CGS Unique No. EP-26-0107

Iron Ridge Filing No. 2 Final Plat

El Paso File No. SF2612

As requested in the County email dated September 15, 2026, CGS has reviewed the Response to Review Comments, Iron Ridge Subdivision Filing Nos. 1 and 2 (Entech Engineering, Job No. 251117, July 31, 2026), and the revised Final Plat (Gould Land Surveying, Project No. 25133, revised September 10, 2026), in response to our July 8, 2026 review. The current Filing No. 2 plat creates 14 rural residential lots on approximately 42.52 acres.

FINAL PLAT
IRON RIDGE FILING NO. 2

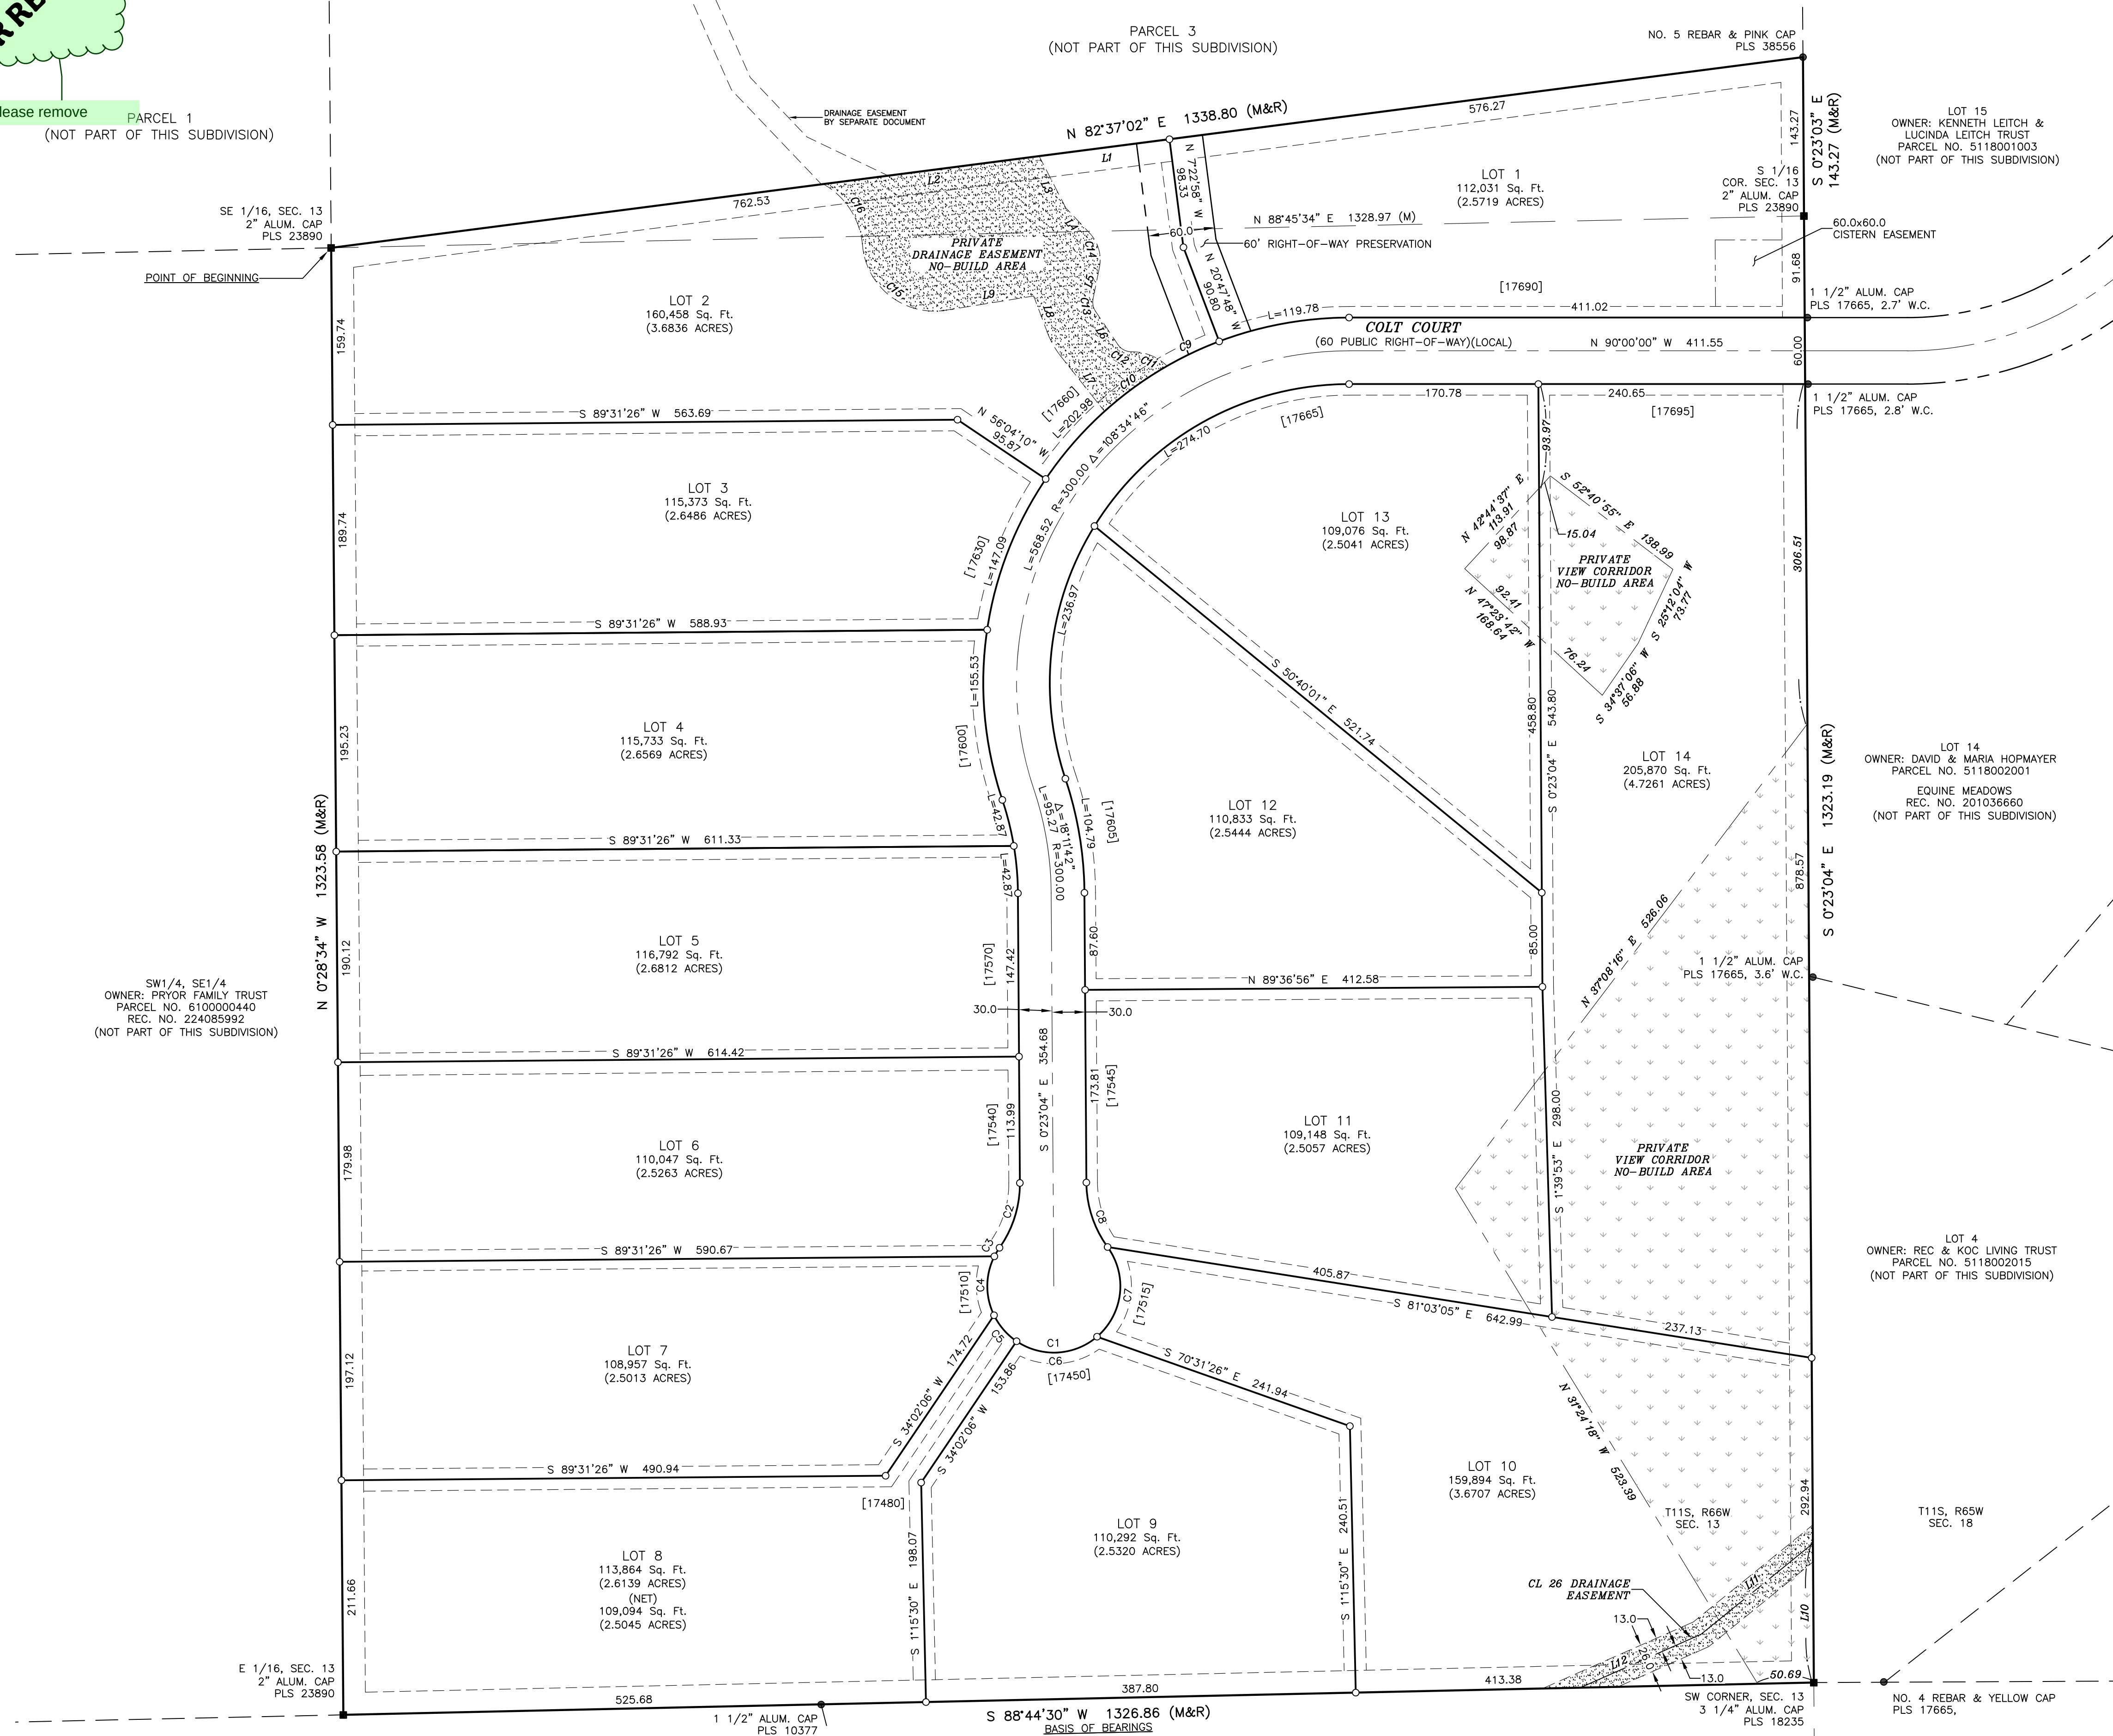
Groundwater and basement feasibility. Before building permit approval, lot-specific soils and foundation investigations should evaluate groundwater conditions for each proposed structure and establish feasibility for proposed basements, considering seasonal monitoring results, local geologic conditions, and proposed grading and foundation elevations. CGS continues to recommend that proposed foundation components remain at least 3 feet above the maximum anticipated seasonal groundwater level. Where adequate separation cannot be demonstrated, CGS recommends not permitting basements. Providing drains does not, by itself, demonstrate that this separation will be maintained.
